RE: Timber Ridge Lot 9 Short Plat (SP-08-00019)

Kittitas County Community Development Services has determined that the Timber Ridge Lot 9 Short Plat (SP-08-00019) is a complete application and hereby grants ***conditional preliminary approval*** subject to the following conditions:

KITTITAS COUNTY
WASHINGTON
PELTON-EDELMAN LOT 9
SP-XX-XX

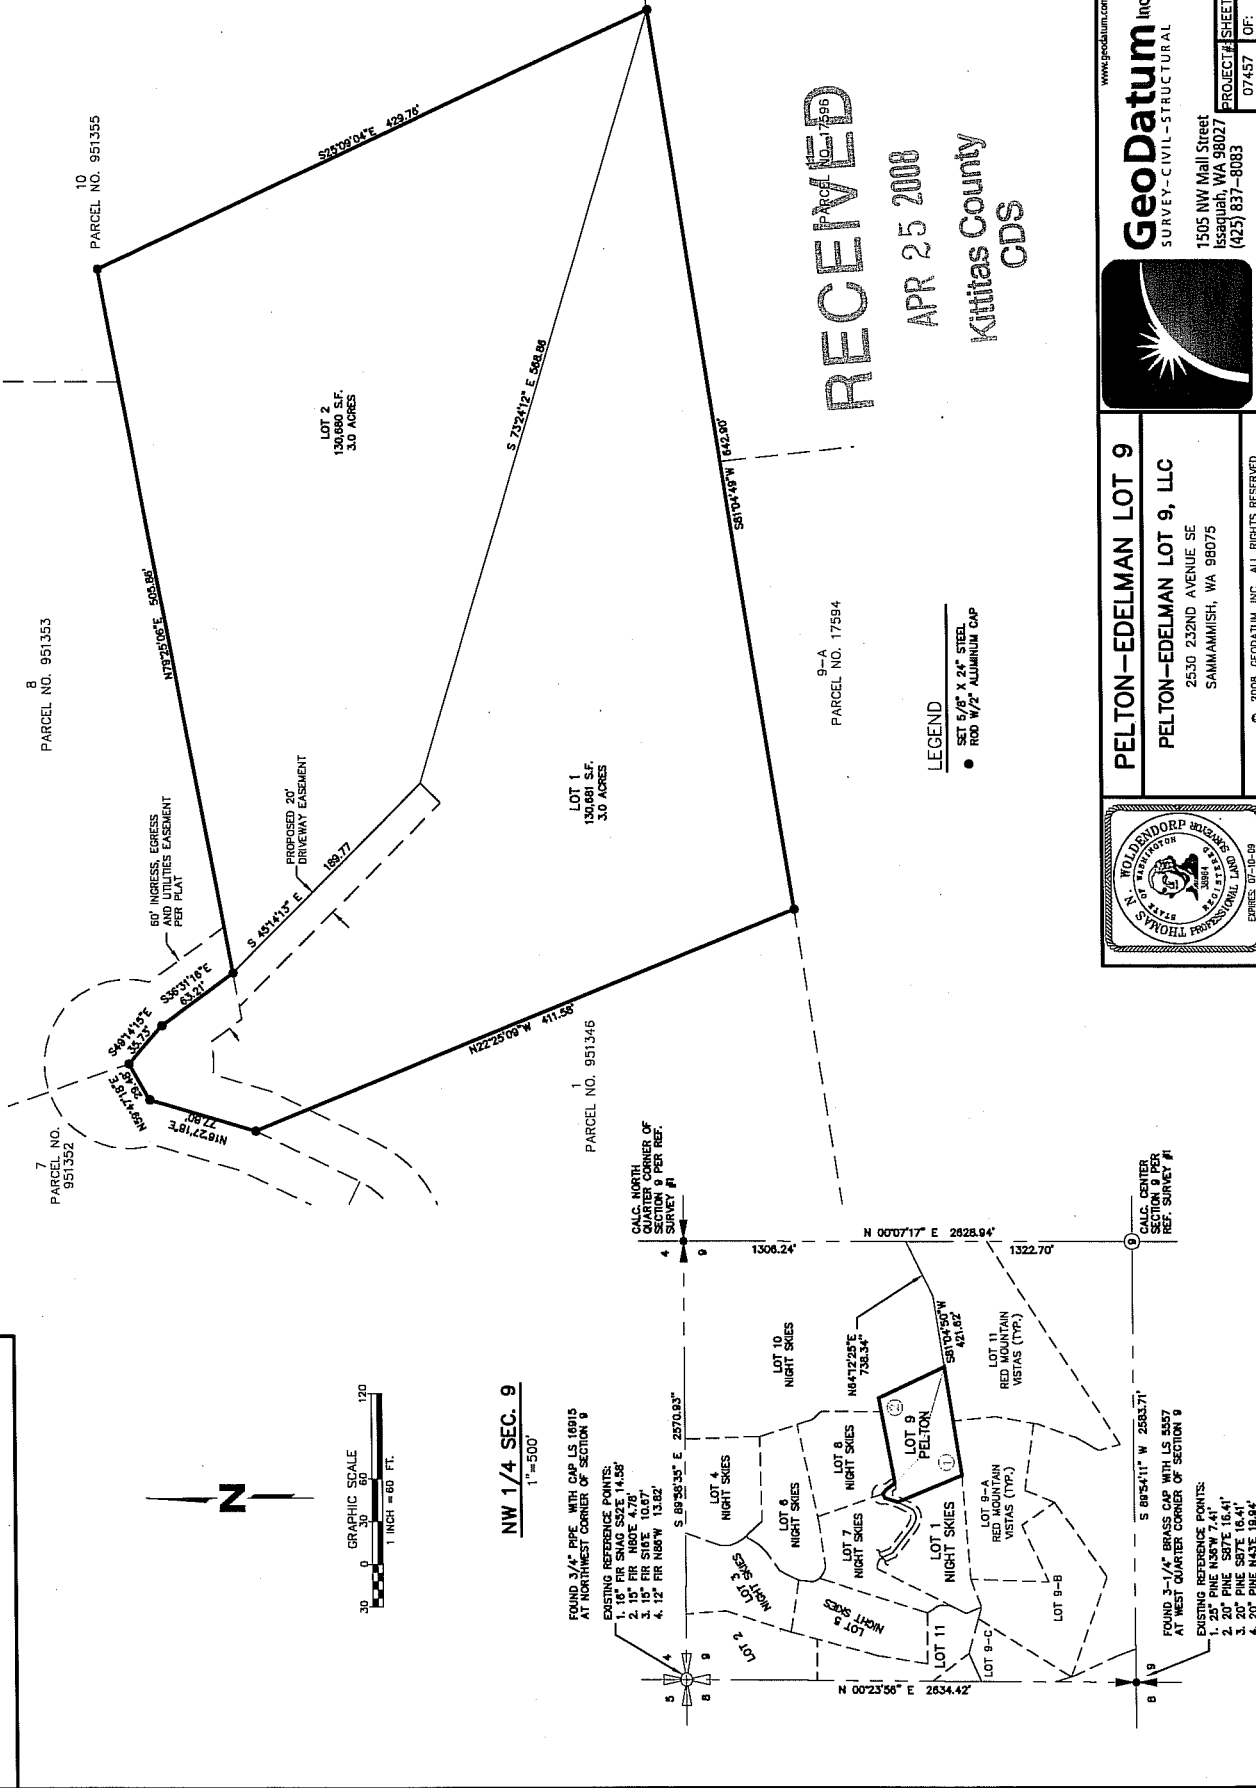
1. Both sheets of the final mylars shall reflect the correct short plat name Timber Ridge Lot 9, short plat number SP-08-00019 and an accurate legal description shall be shown on the face of the final plat.
